**Air Quality Representation by
Prof. Duncan Laxen,
on Behalf of Royal Horticultural
Society, Wisley:**

**For DCO Hearings for M25
Junction 10/A3 Wisley
Interchange Improvements**

November 2019

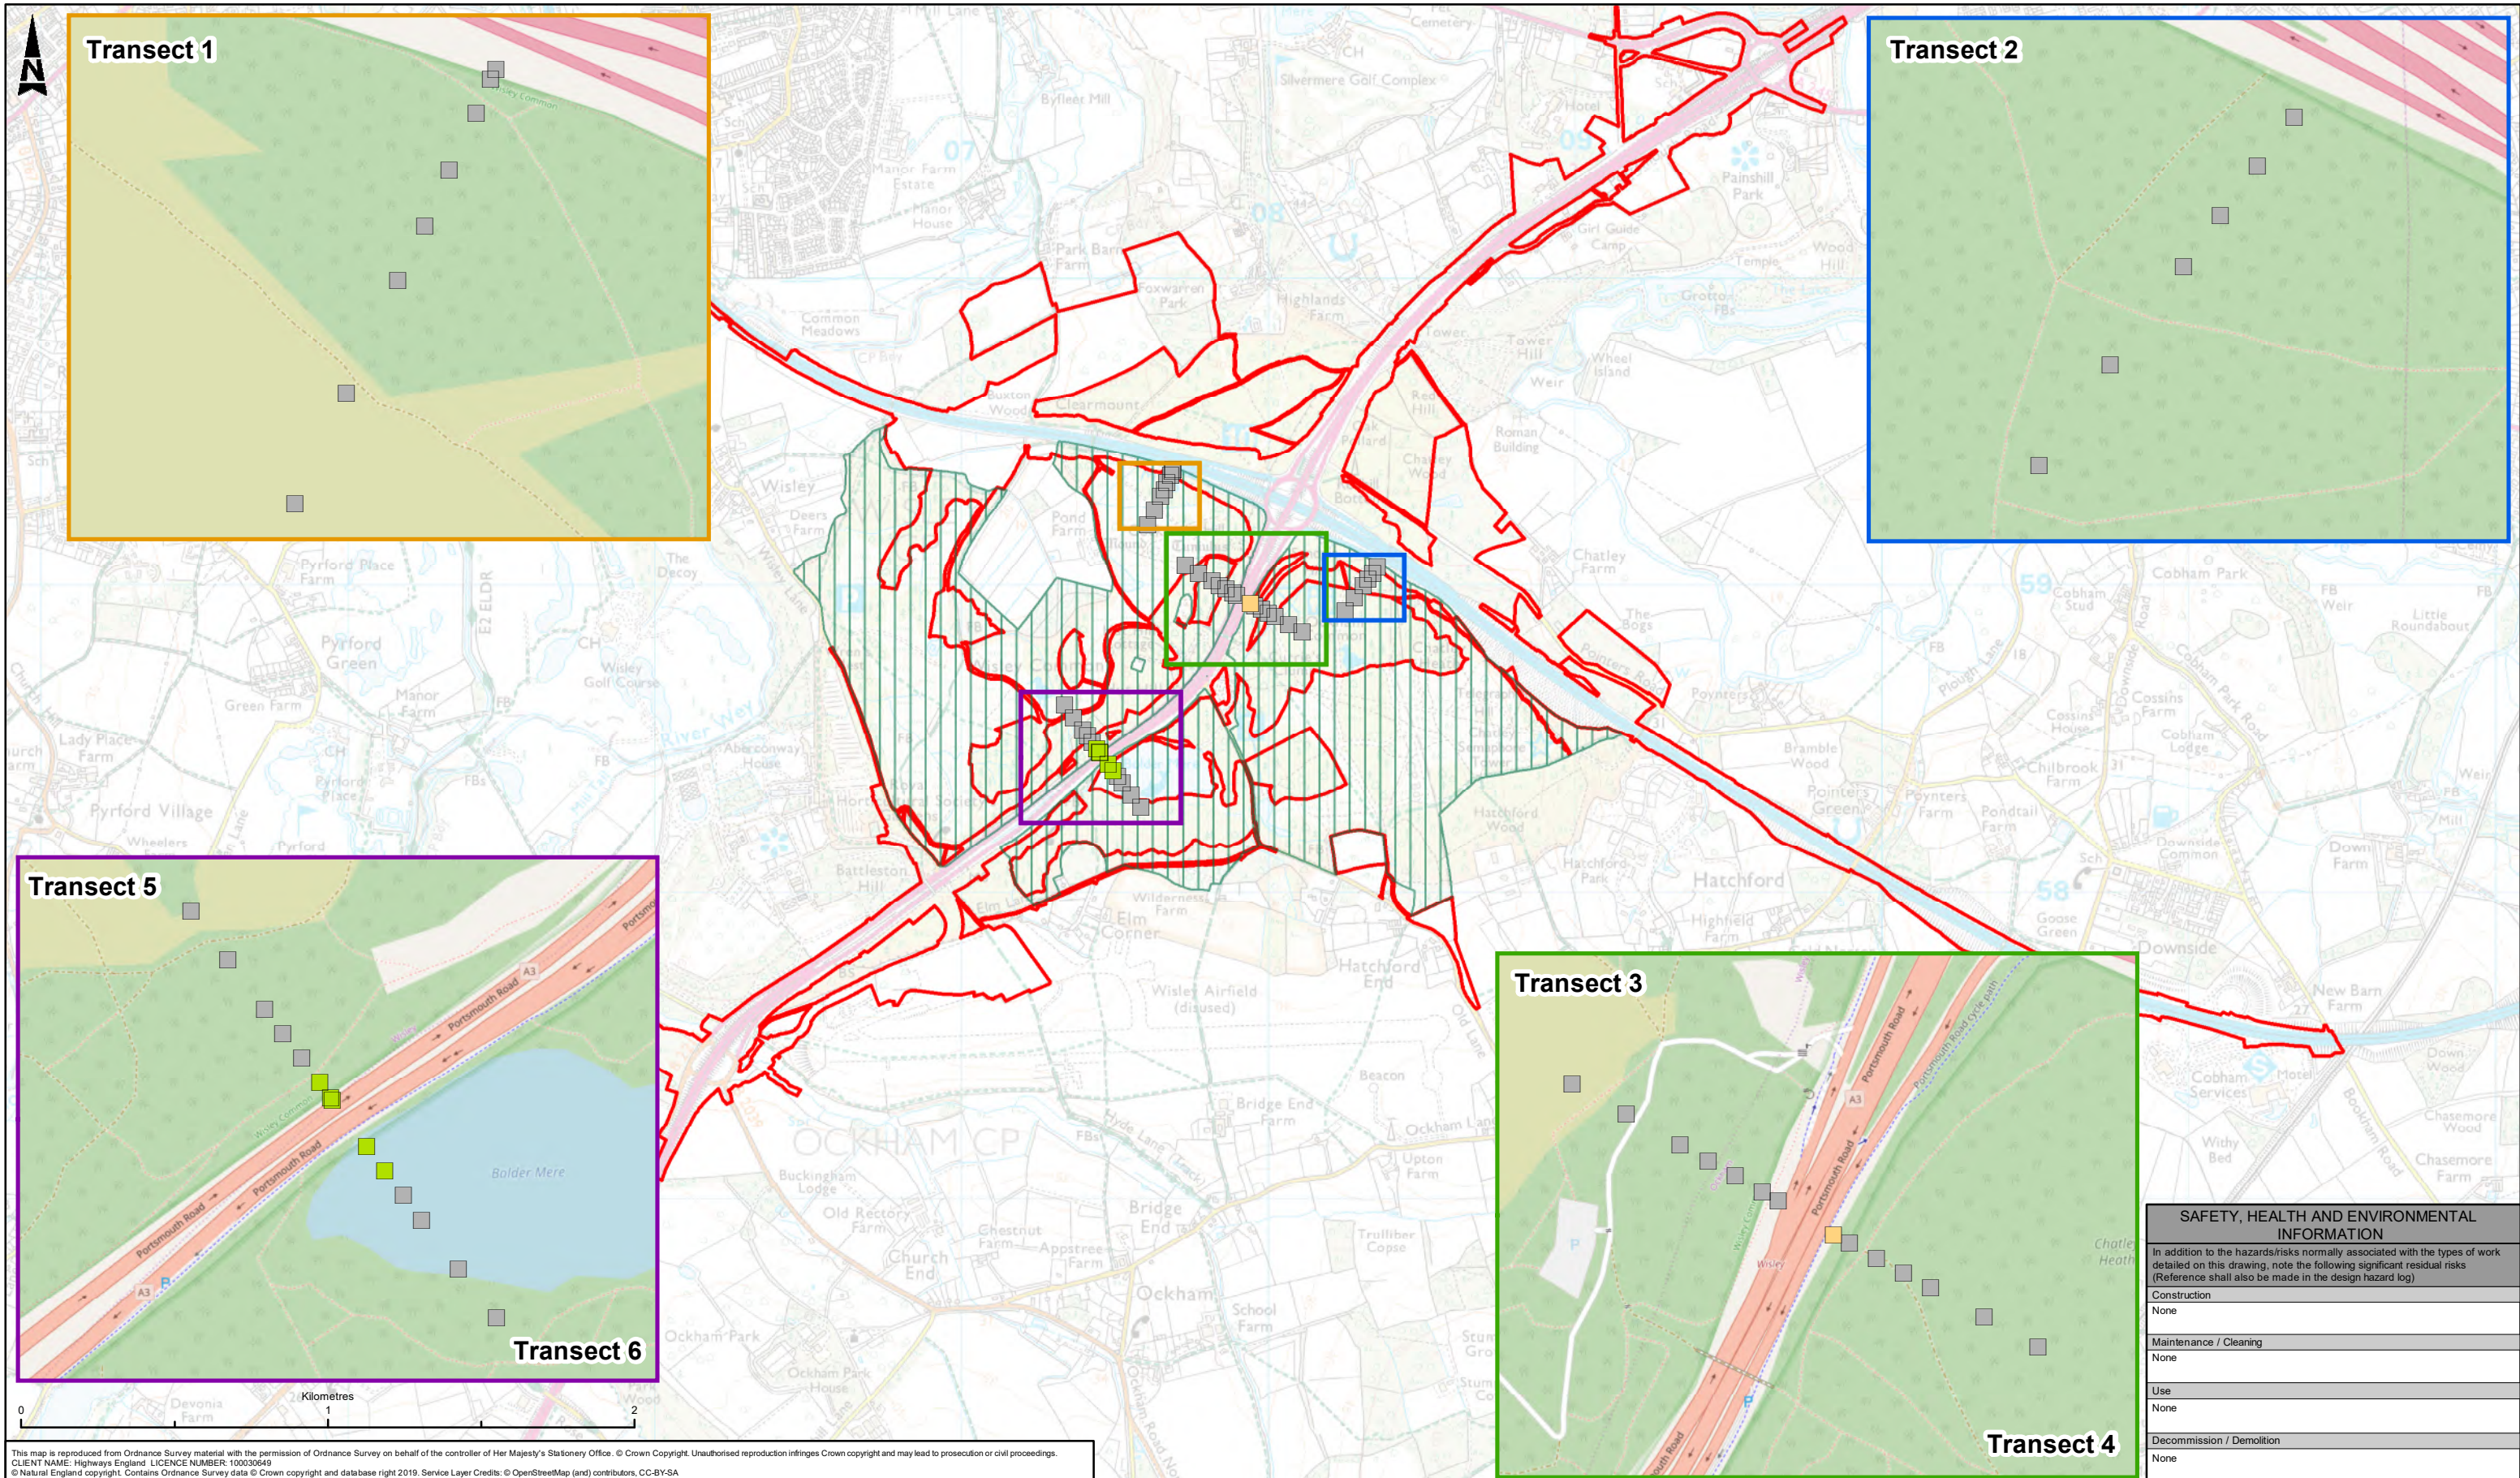
- 3.4 The Ndep rates calculated for these same receptors alongside the A3 are set out in the Statement to Inform Appropriate Assessment (“SIAA”) (APP-043) as transects 3 and 4 in Table 8 (page 41). The increases, due to the DCO Scheme alone, range up to 1.1% of the Critical Load to the west of the A3, and up to 1.6% to the east. In both cases the Ndep rates are well above the critical load of 10 kg/ha/yr at all receptors, and rise to 15.2 kg/ha/yr (west) and 16.1 kg/ha/yr (east). The importance of the exceedances of the critical load is discussed by Andrew Baker in his written representation (see in particular paras 15 to 19 and 23 in RHS/AB/1).
- 3.5 A significant part of these increases in NO_x concentrations and Ndep rates within the SPA will be due to the additional vehicle movements undertaken by RHS visitors, as required by the DCO

- 3.8 The SIAA (APP-043) fails to consider the impacts of the DCO Scheme on NOx concentrations within the SPA as part of the assessment, even though NOx concentrations are included in the Air Quality Assessment (APP-050). No reason for this omission is provided. **In my view HE should be required to include NOx concentrations, assessed against the critical level, as part of the SIAA, as without this information the relevant authority will be unable to complete the Appropriate Assessment.**

Figure 4.1: Location of additional receptors in Ripley

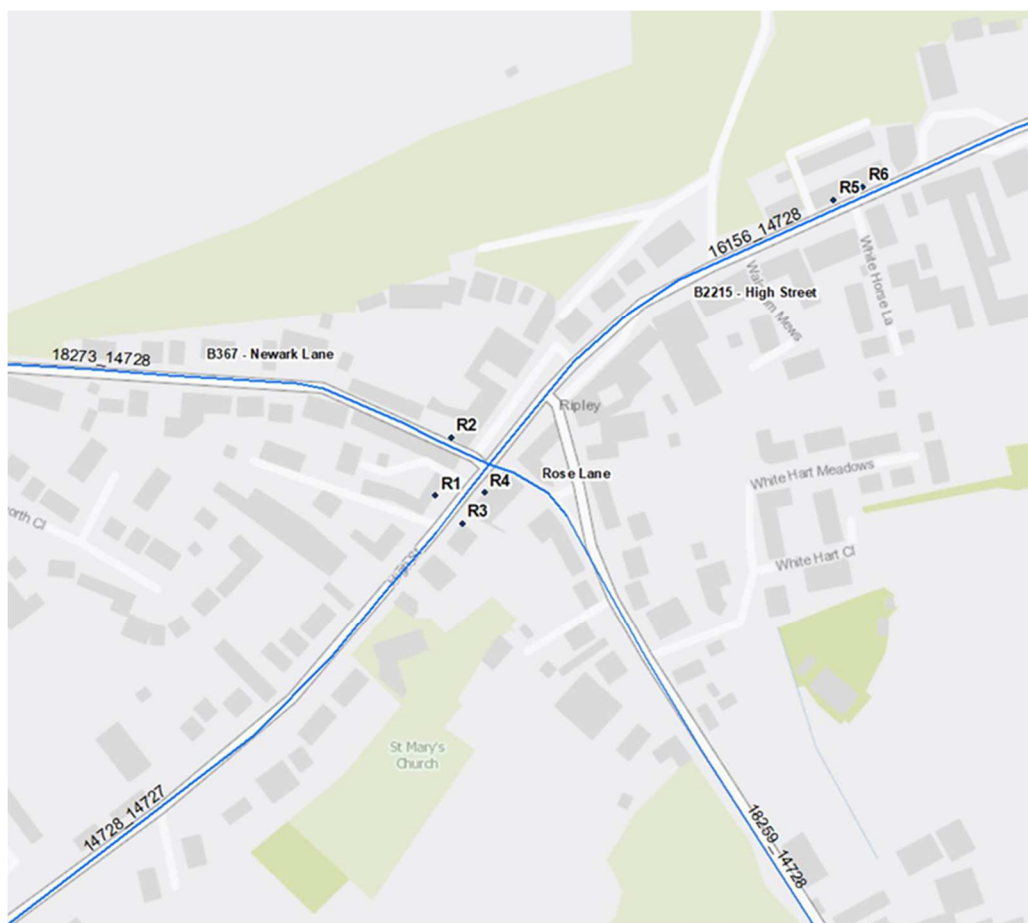
- 5.3 The Air Quality Assessment identified only one receptor within Ripley, R59, shown in Figure 5.10 sheet 3 of 4, in APP-065, and described in Table 5.2.1 in APP-080 as Aberdeen House, High Street Ripley (Grid Ref 505165, 156748). The location of this receptor has recently been shown in greater detail on a map provided by HE in response to questions from RHS (this is reproduced in Appendix A7 on page 28 of this report). However, the location is not Aberdeen House, which is around 30m to the northeast. The distance is given as 11.3m from the kerb of High Street and 6.7m from the kerb of Newark Lane. Concentrations decline rapidly on moving away from the kerb and there are receptors closer to the road in Ripley that should have been selected. For instance, further to the east along the High Street, there are properties around 1 to 2m back from the kerb (see photographic evidence in Appendix A8 on page 29 of this report). There are also properties around 1m from the kerb of Newark Lane, which is canyon like and will hence have higher concentrations, near its junction with High Street (see Appendix A8). Concentrations 1 to 2m from the kerb will be significantly higher than those Fh7 to 11m from the kerb. HE has therefore not selected worst-case receptors in Ripley. The DMRB makes clear in para 3.16 that worst-affected properties should be identified (see extract reproduced in Appendix A9, on page 31 of this report). **In my view HE should be required to include receptors in Ripley where the impacts will be**
